March 2, 2017

Re: Structural Review of Existing Foundation  
5 Brookside Road  
Portland, ME 04103

SK-1 BASEMENT PART. PLAN  
1/4" = 1'-0"

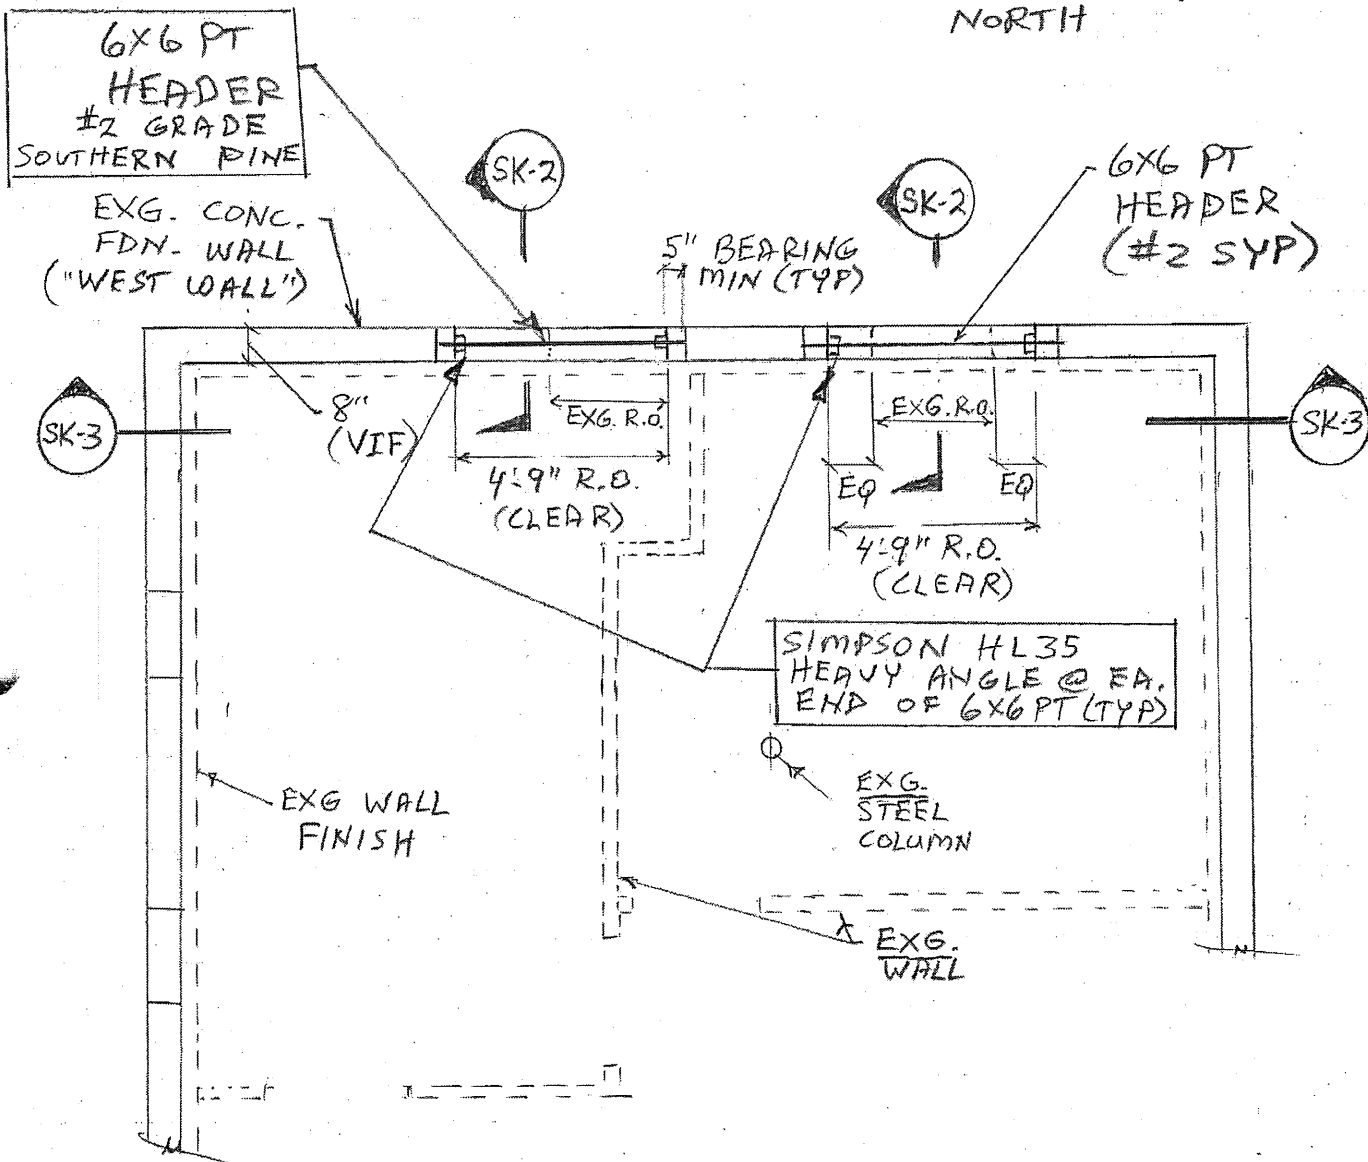
1. The enlarged basement windows will be installed at the side of the house closest to Ocean Avenue (west side)
2. The 1-story house was approximately 24' wide in the north/south direction at the west wall.
3. The foundation was constructed of concrete and the walls were approximately 8" thick.
4. The inside surface of the foundation wall at the west end could not be observed since it was covered with finishes.
5. The top 2'-6" portion of the west foundation wall could be observed from the exterior. No severe fractures or other evidence of foundation degradation was observed at the accessible areas of the west foundation wall.

- The foundation wall at the west side is sufficiently adequate to support the installation of the enlarged windows.
- The header spanning across the top of each window should be a 6 x 6 pressure-treated southern yellow pine, #2 grade or better per the attached stamped notes and details.
